KITTITAS COUNTY COMMUNITY DEVELOPMENT SERVICES

RE: Garrison Boundary Line Adjustment (BL-18-00006) – Additional Information Requested

Parcel # 106634	Map # 19-16-08040-0019
Parcel # 946634	Map # 19-16-08040-0024
Parcel # 266634	Map # 19-16-08040-0025

# BLA EXHIBIT

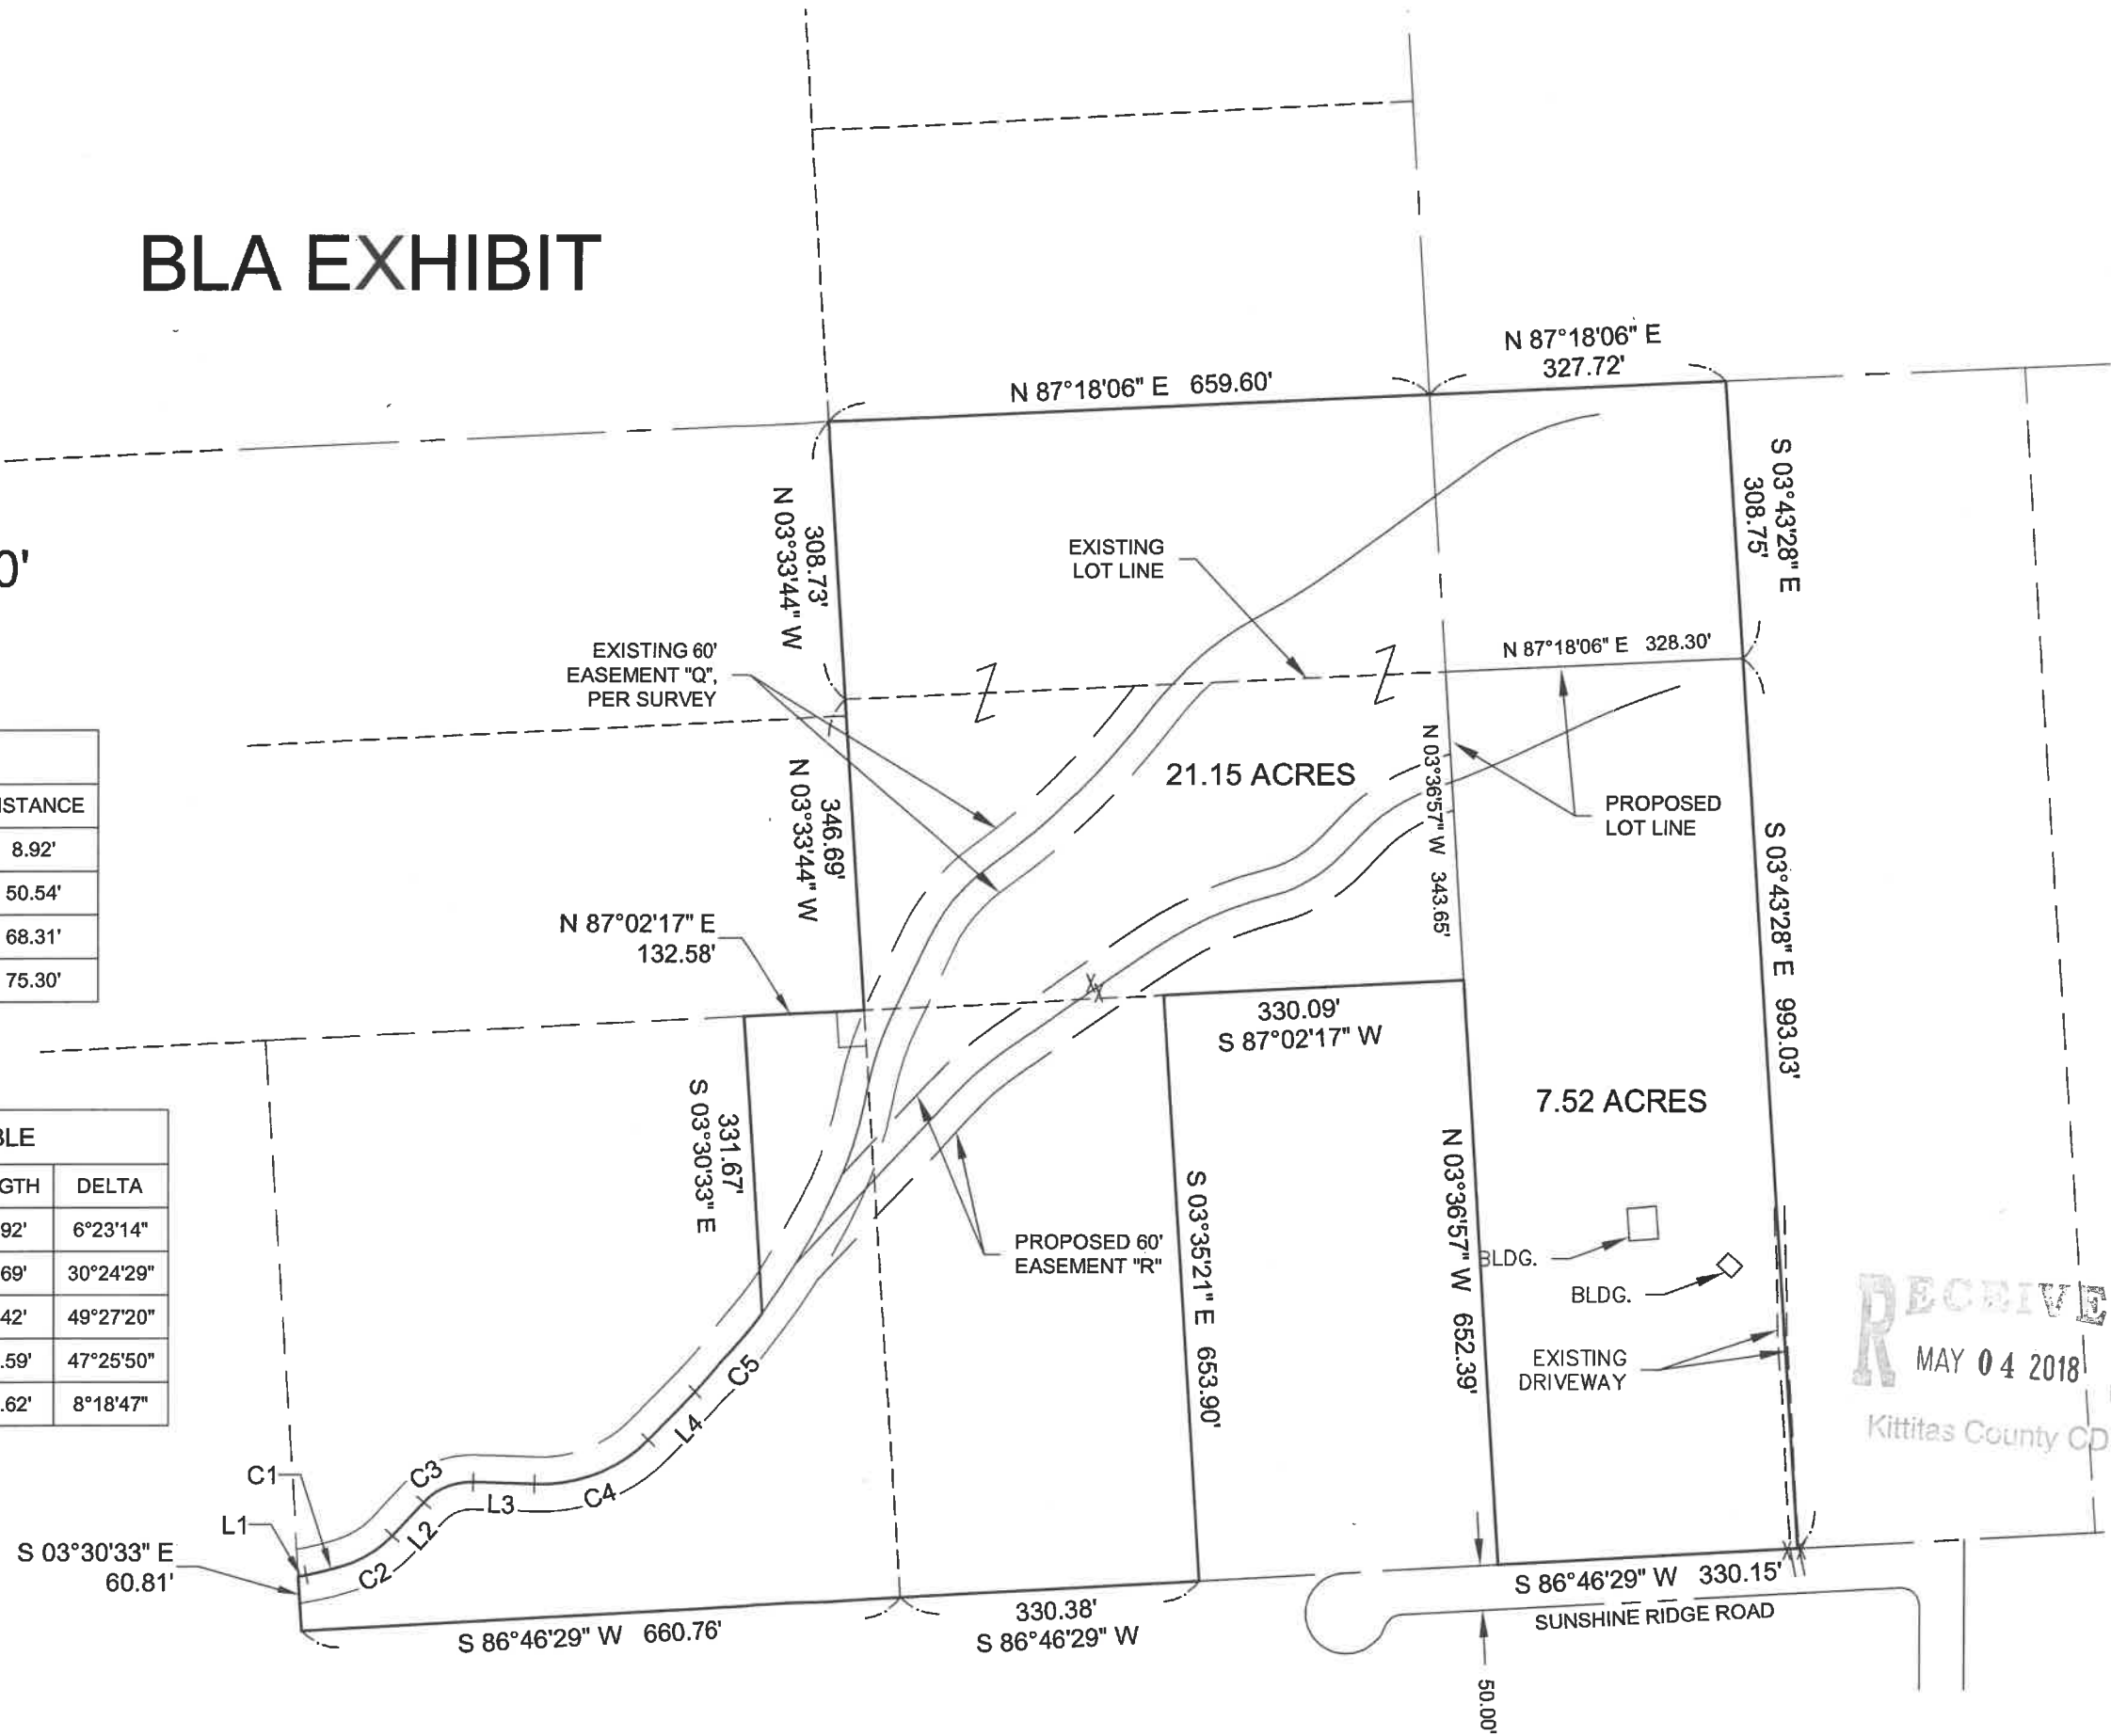
Based on the comments received, additional information is necessary before processing of your application can continue. Please provide the following as requested by Kittitas County Environmental Health:

- A revised site plan clearly depicting the locations of any septic systems and drainfields.
